Our Ref: 20/01239/HOU
Your Ref:

LOCATION: 28 Everdon Lane, Portsmouth, PO3 5UA, ,

PROPOSAL: Garage conversion to habitable accommodation **(20/01239/HOU)**

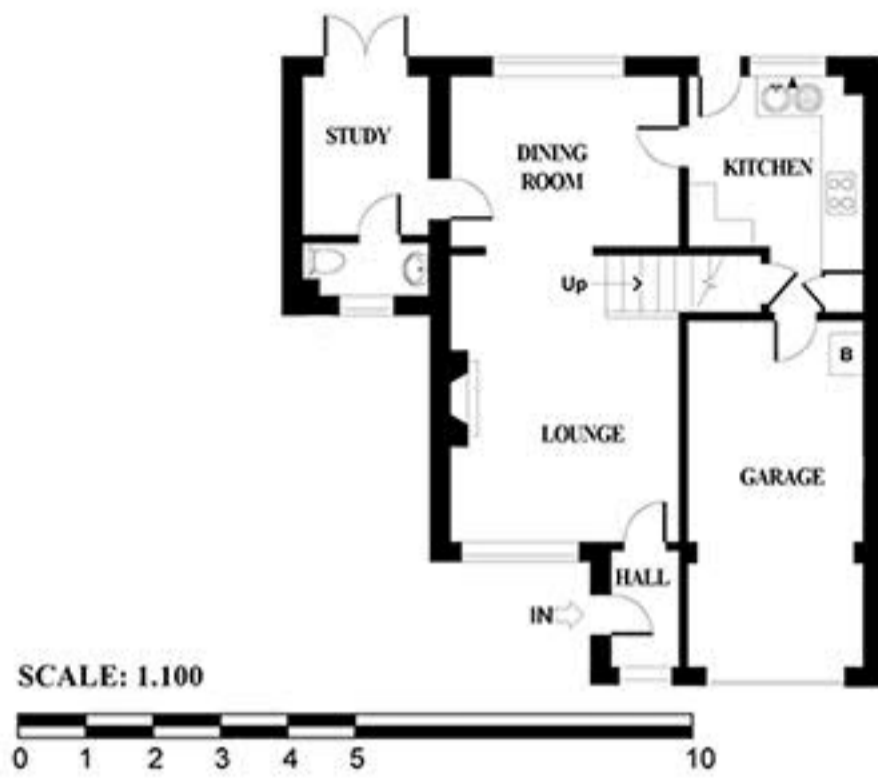
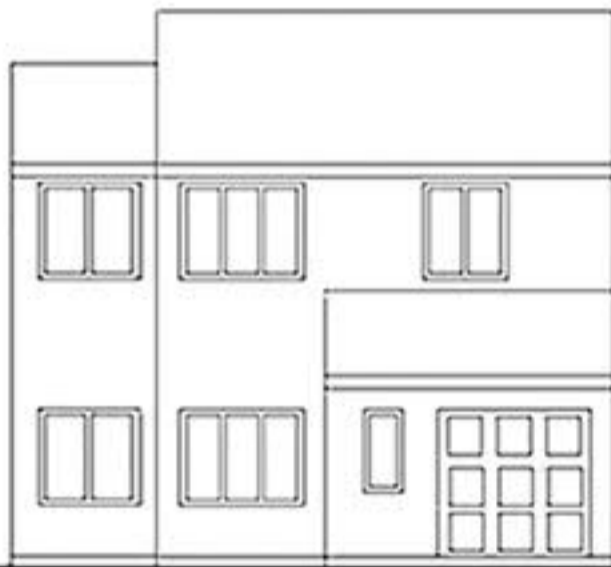
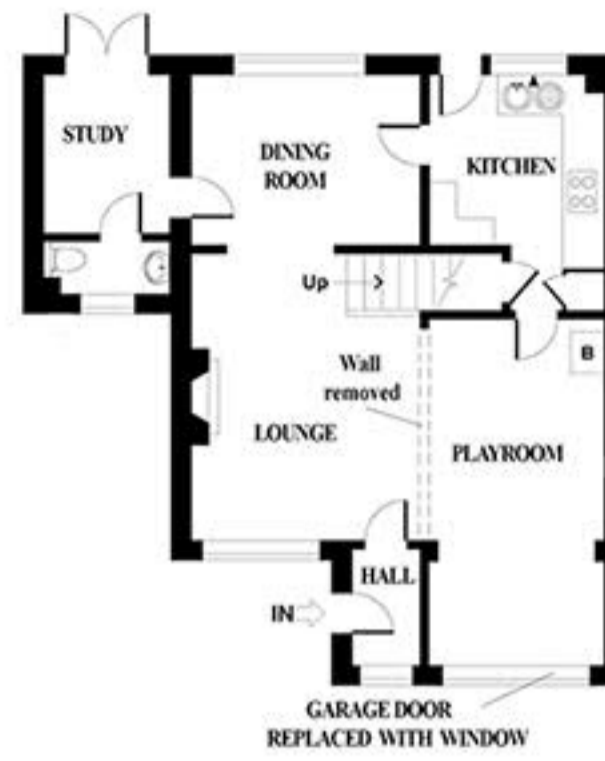
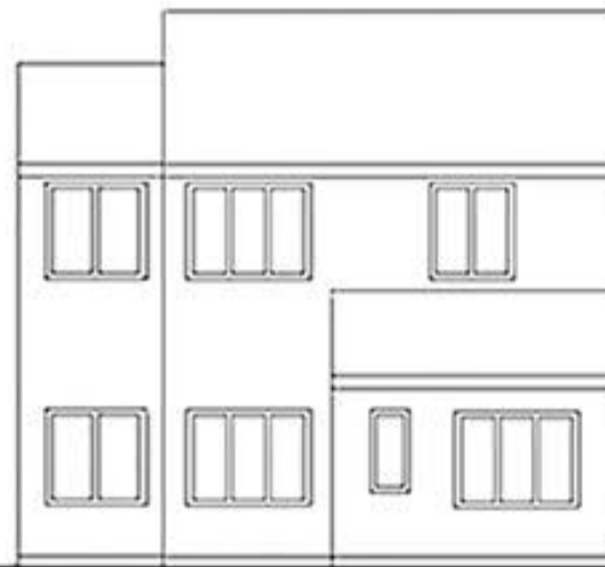
- 1) It is a requirement that all drawings are accompanied by scale bars for every sized used. Please resubmit your drawings with the appropriate scale bar(s) included.
- 2) Please provide the elevations showing the proposal/alterations. Please submit this at a stated standard metric scale such as 1:50 or 1:100, with a scale bar or dimensions annotated to allow the confirmation of the scale
- 3) This application attracts a planning fee and this must be submitted, the correct fee required is £^.
- 4) The proposed site falls within a flood zone you are therefore required to submit two copies of the flood risk assessment. The appropriate forms can be found at the following link <https://www.portsmouth.gov.uk/wp-content/uploads/2020/05/development-and-planning-flood-risk-assessment-and-information-form.pdf>
